Your Ref: 2025/90459

Our Ref: A007827

Private Car Park, Sheepridge Road, Sheepridge, Huddersfield - (Kirk) Discharge of details reserved by condition 4 (drainage) of previous permission 2022/90464 for use of land for car wash and access works to create one-way system

TITLE: OVERALL SITE LAYOUT AND CONTOUR PLAN

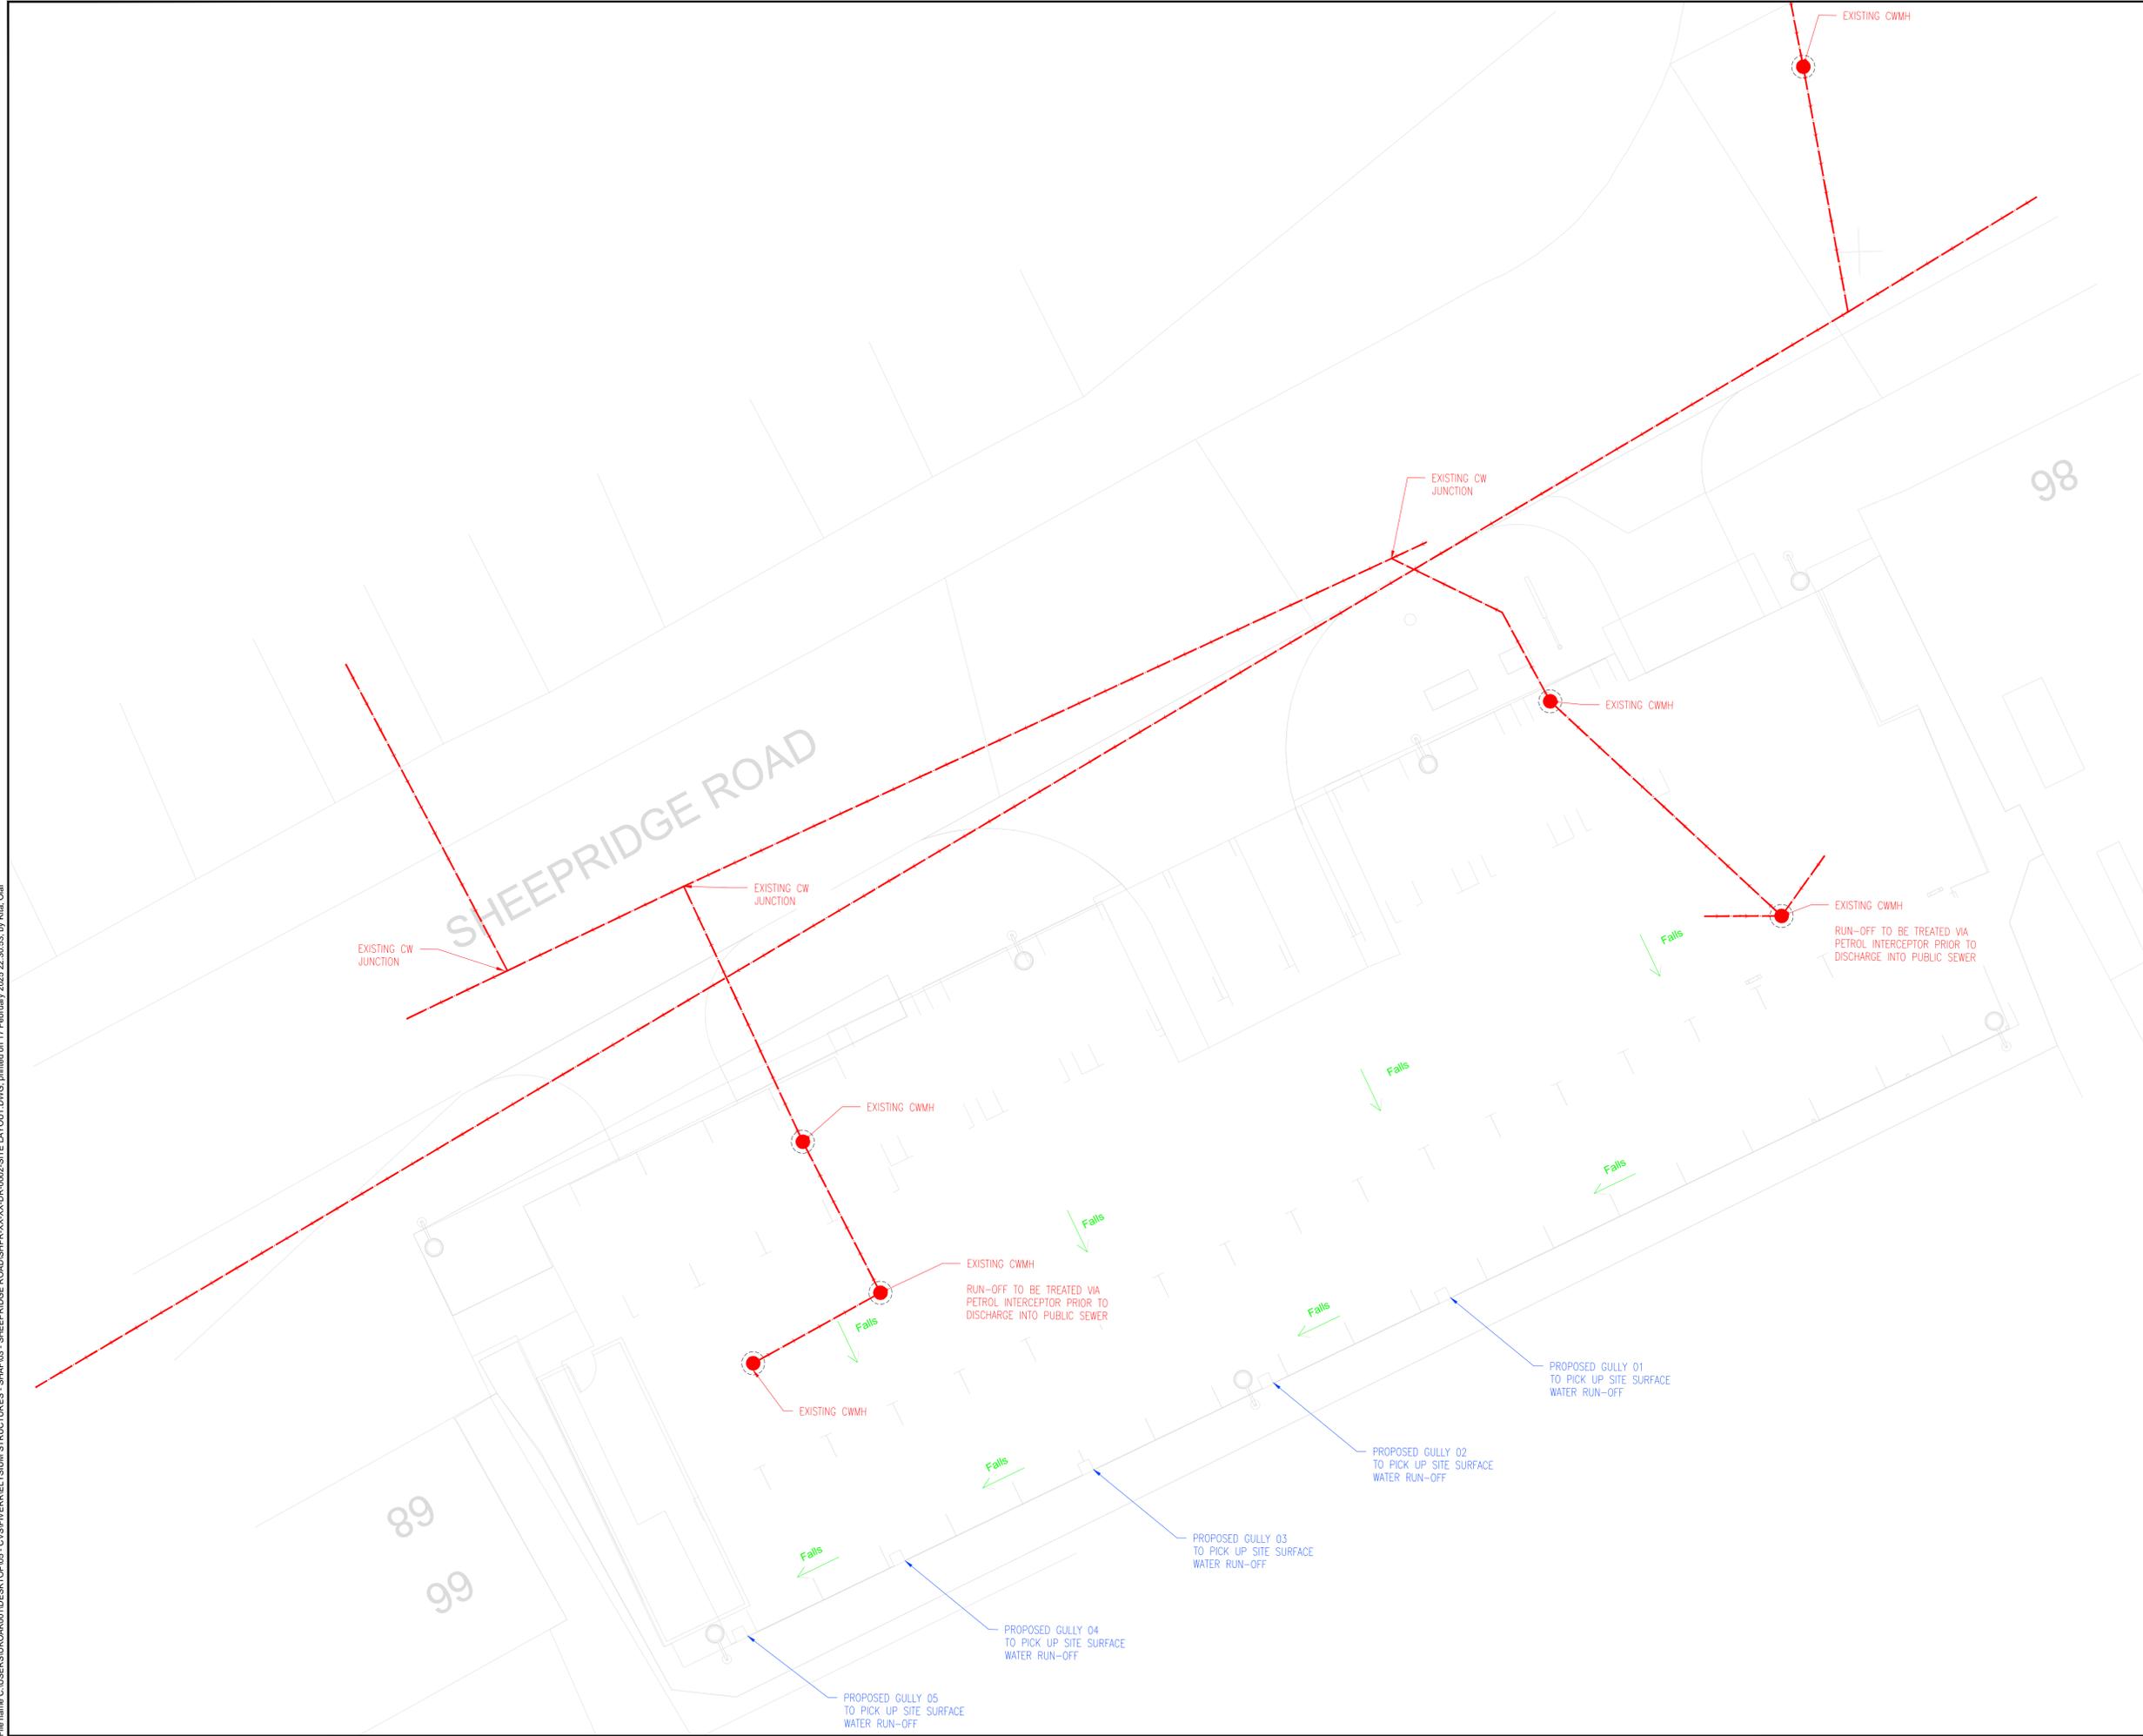
1.) The drainage details submitted on drawing 'OVERALL SITE LAYOUT AND CONTOUR PLAN' SHRP-00-CV-DR-00 (revision C01) dated January 2025 that has been prepared by Kita is not acceptable. The following point(s) should be addressed:

a.) the submitted drawing appears to show existing drainage and proposed gullies, but not how the two discharge to one another, nor where/ how discharged cleaning water run-off will be treated by interceptor - a full proposed drainage drawing should be prepared.
